Our Ref: PAA/54/14/

Pre-Application Advice

Replacement Dwelling

19 Oval Way Ferring

SITE SURVEY

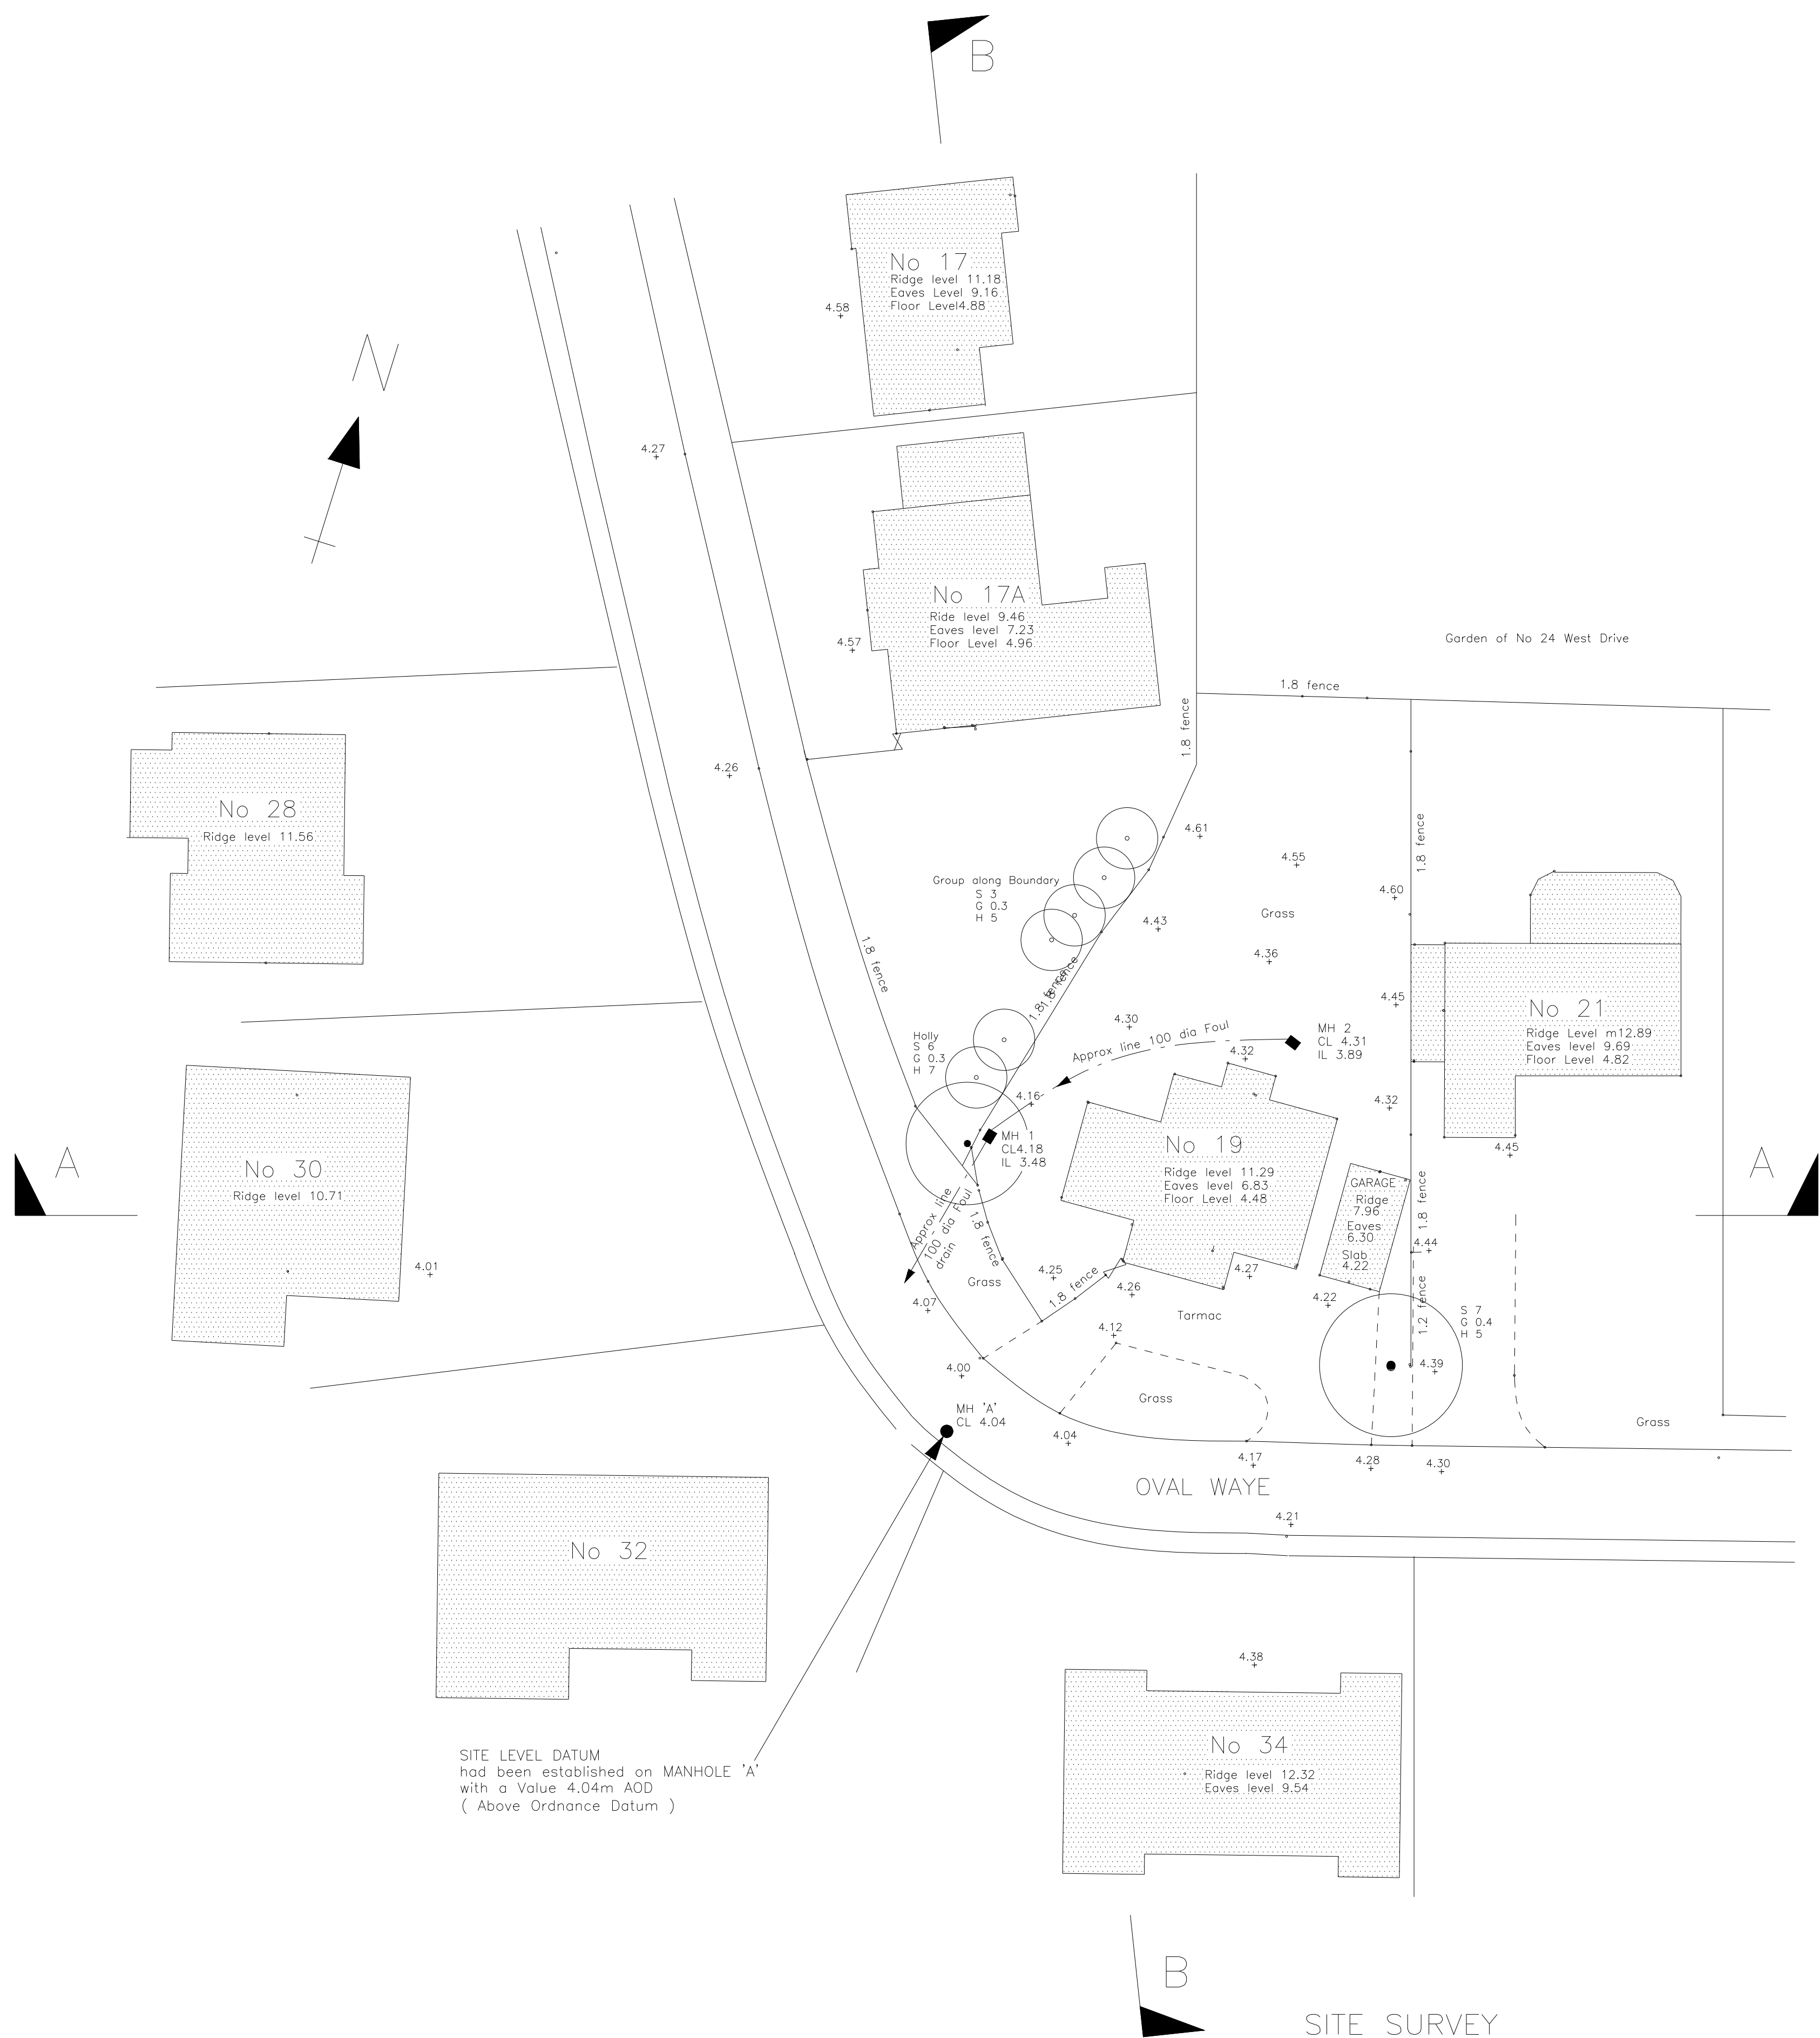
There is however concern regarding a two storey dwelling of the proposed size being in such close proximity to the road, especially given the prominence of the site on the bend of Oval Way. The immediately surrounding properties of Nos. 21, 26 and 30 are set farther back from the road than the proposal. This set back is also observed for two storey detached properties to the north of the property in Oval Way. Whilst No. 17A is situated in close proximity to the road, it is a detached bungalow and so is not directly comparable to the proposal. Consequently, it is considered that the dwelling would benefit from being moved back from the road by 1-2m, even if this means sacrificing the full width of the property or the detached garage to side due to the narrowing shape of the plot. This would then reduce the prominence of the two storey detached

dwelling and make it more acceptable in the street scene. By setting the proposal back by this distance, the necessary 10m depth of the rear garden would still be met which is a requirement of the External Space Standard policy D DM3 of the Emerging Local Plan. Depending upon the final set back distance, a condition may be applied to any planning permission to secure supplementary planting to the front of the property to reduce its prominence in the street scene.

GROUND FLOOR

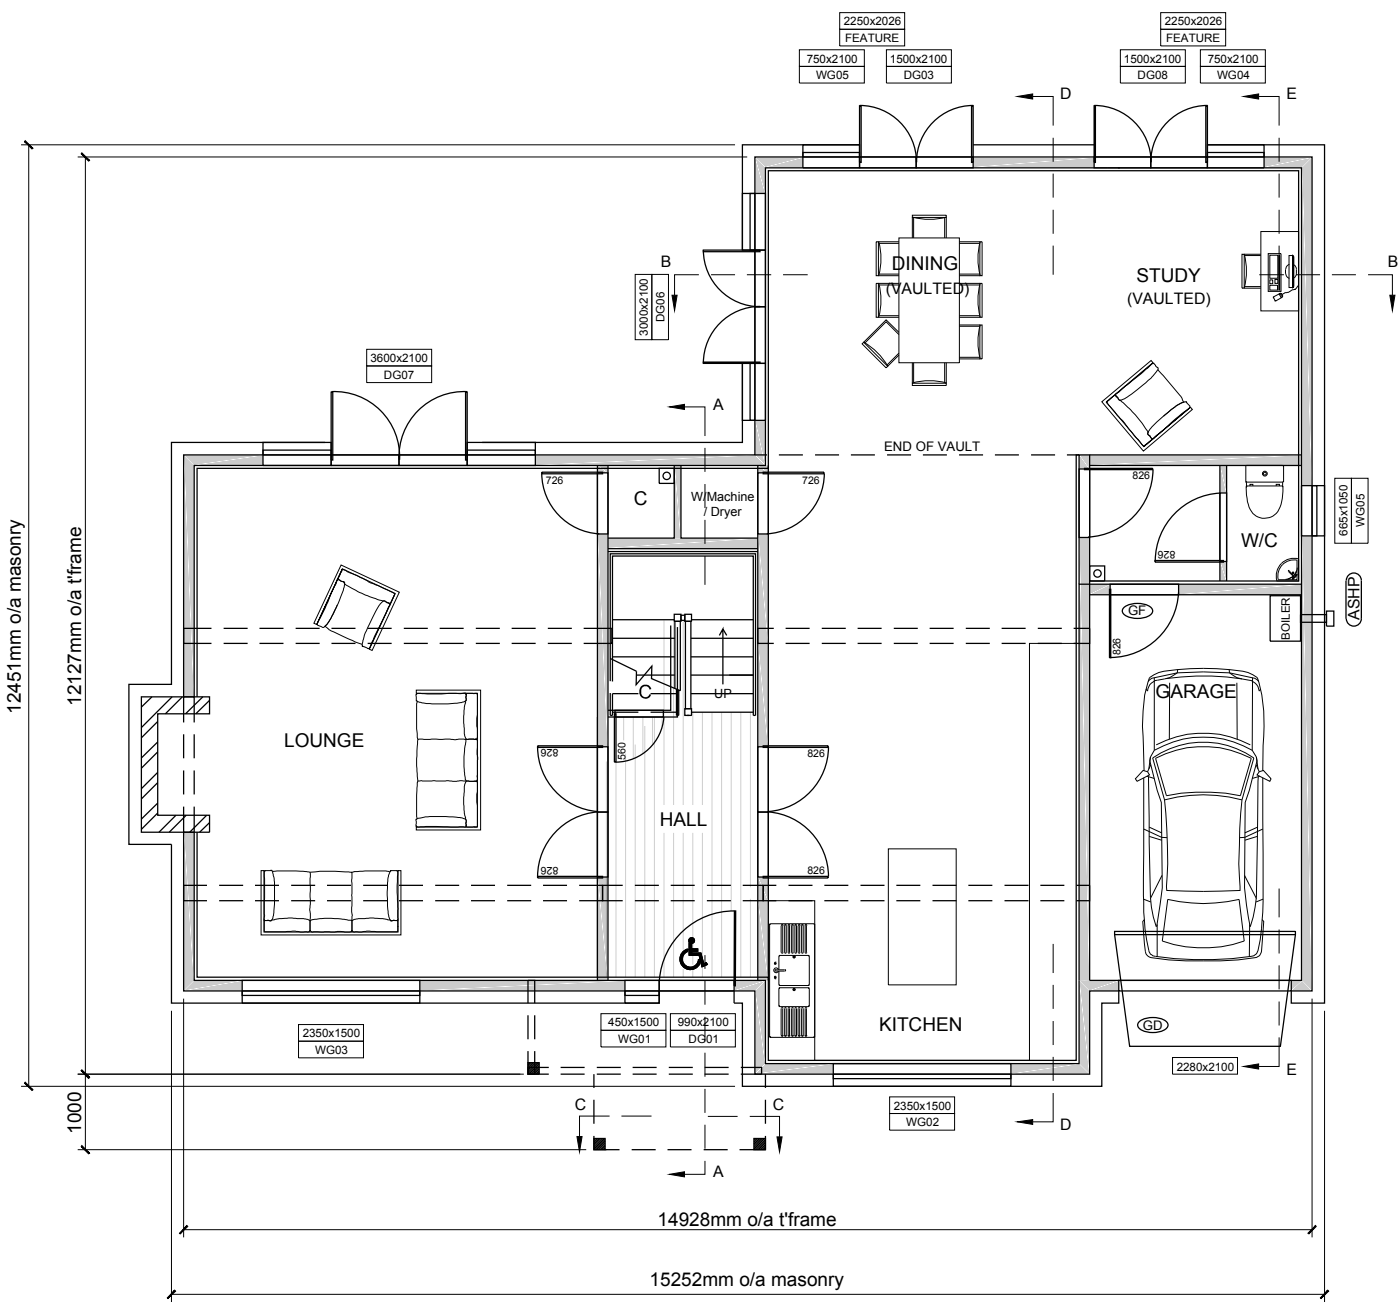
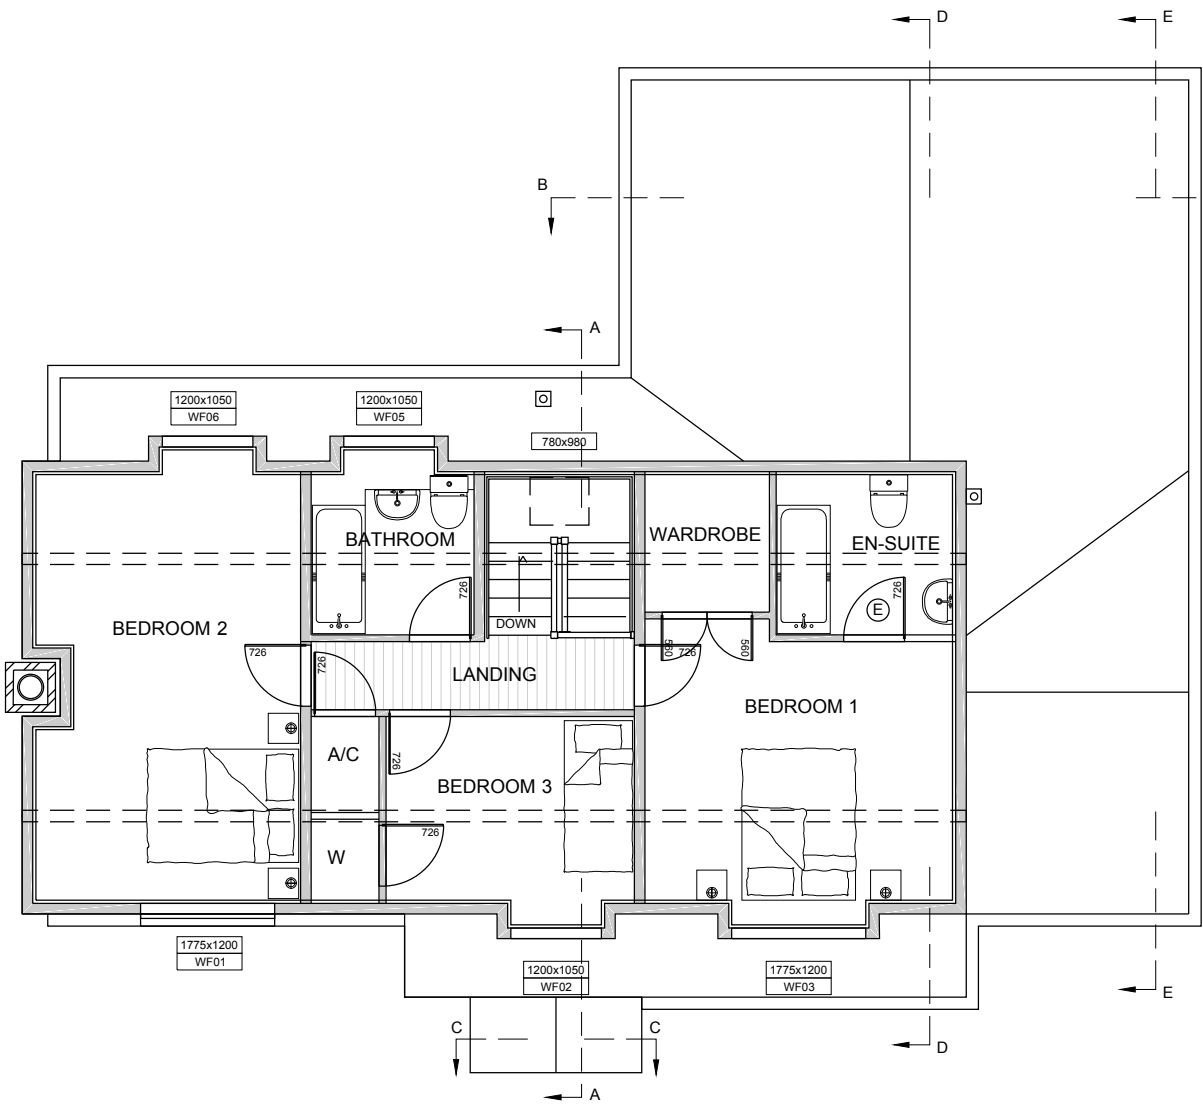
In terms of Internal Space Standards (policy D DM2) of the Emerging Local Plan, the proposed room sizes meet the stipulated requirements, apart from the small shortfall for Bedroom 1 at 10.85 sq m (should be 12 sq m) and a bathroom at 5.22 sq m (should be 6.8 sq m). Provided that Bedroom 3 is a single room, this is judged acceptable with the requirement of 8 sq m.

Based on the above comments I conclude that were an application for planning permission to be submitted it is likely to be approved, subject to amending the position of the replacement dwelling further back from the road and addressing the shortfall on room sizes for Bedroom 1 and the first floor bathroom. The appearance of the property is considered acceptable in design terms within the road and is unlikely to cause any harmful residential effects at least in principle.
